Hornsea Project Three
Offshore Wind Farm

Statement of Common Ground between Hornsea Project Three
(UK) Ltd. and Highways England

Date: January 2019

Figure 2.1 – Crashmap A47/Taverham Road Junction Assessment

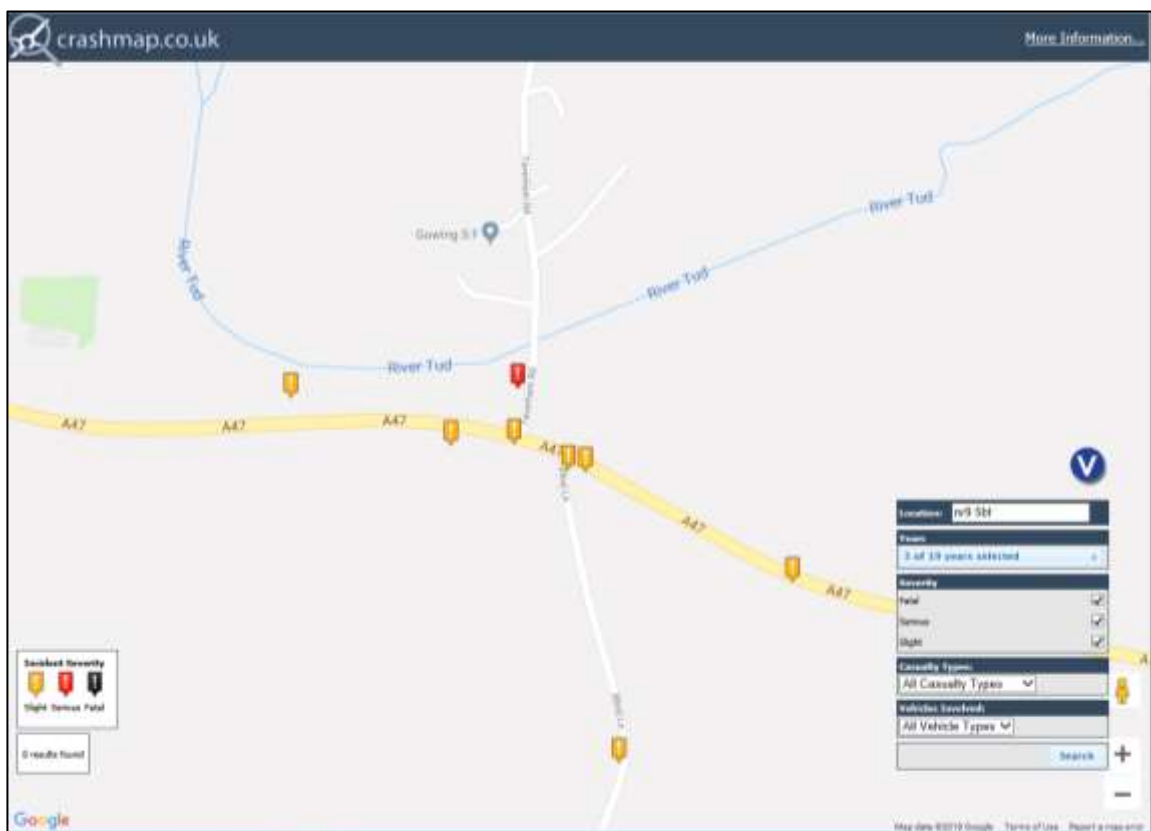
Table 1.5 of the TA lists two construction site accesses as being accessed via the A47/ Taverham Road junction. These are listed as sites 16 (B) and 17 (B) although on the plan at Sheet 7 of ES Annex 7.8, it would seem more logical to serve sites 17 (B) and 18 (B) from Taverham Road and 16 (B) from Church Lane, Easton. Appendix A shows the total traffic generated by sites 16 (A), 17 (B) and 18 (B) as being 31 two-way light vehicle and 99 two-way HGV movements per day. It would be reasonable to assume that this traffic will be split equally across the three access points, therefore the A47/ Taverham Road junction would have to accommodate up to 66 two-way HGV movements per day. This is unlikely to require a junction capacity model. However, the underlying suitability of this older-style priority junction needs to be questioned for the reasons stated at para 24 above. An assessment of the junction’s layout against DMRB standards and the provision of HGV swept path plots to demonstrate its adequacy to accommodate an influx of larger vehicles, together with an assessment of the collision record here would be advisable. It is of note that a collision analysis was undertaken for the A47 to the west of Easton (TA paras 1.4.2.16 – 1.4.2.23) but this covered a section some 2-3km to the west of here and did not include this junction.

Further assessments as recommended above would be beneficial. Alternatively, from the perspective of the safe and free flow of traffic on the Trunk Road, it might be preferable to serve all three access points 16(B) 17(B) and 18(B) from the A47/ Easton roundabout via Church Lane (highway link 126) rather than from Taverham Road (link 125).”

- 4.25 To address the AECOM concerns regarding the A47/Taverham Road junction a review of road safety has been carried out using the “Crashmap” recorded personal injury accident database. The review includes three years of accident data to the end of 2017 as shown in Figure 2.1 below:

- 4.26 The Crashmap data depicted in Figure 2.1 shows that only one accident occurred on the A47 immediately adjacent to the Taverham Road junction. This accident is classified as ‘Slight’ in severity and was recorded on the 15 January 2016 involving two vehicles resulting in one casualty.
- 4.27 Figure 2.1 also shows an accident recorded on Taverham Road approximately 35m north of the junction with the A47. This accident occurred on 26 July 2017 and is classified as ‘Serious’ in severity involving two vehicles and one casualty.

- 4.28 The next closest accident to the A47/Taverham Road junction was recorded on 4 May 2018, approximately 50m to the west on the A47. This incident was classified as 'Slight' in severity involving two vehicles and two casualties.

- 4.29 The two accidents shown to the east of Taverham Road along the A47 are more closely linked to the Blind Lane junction to the south and therefore are not relevant to this assessment.

- 4.30 In addition to the Crashmap data analysis outlined above, further analysis has been undertaken using collision data obtained from Norfolk County Council for an extended five year period to the end of August 2018, included at Appendix C. This more detailed account of collision data shows there to be no issues with HGV traffic turning to/from Taverham Road within the immediate vicinity of the A47/Taverham Road junction.

- 4.31 Consequently, it can be asserted that there are no prevailing accident issues associated with the A47/Taverham Road junction arrangement and this is likely to remain so with the introduction of Hornsea Three.
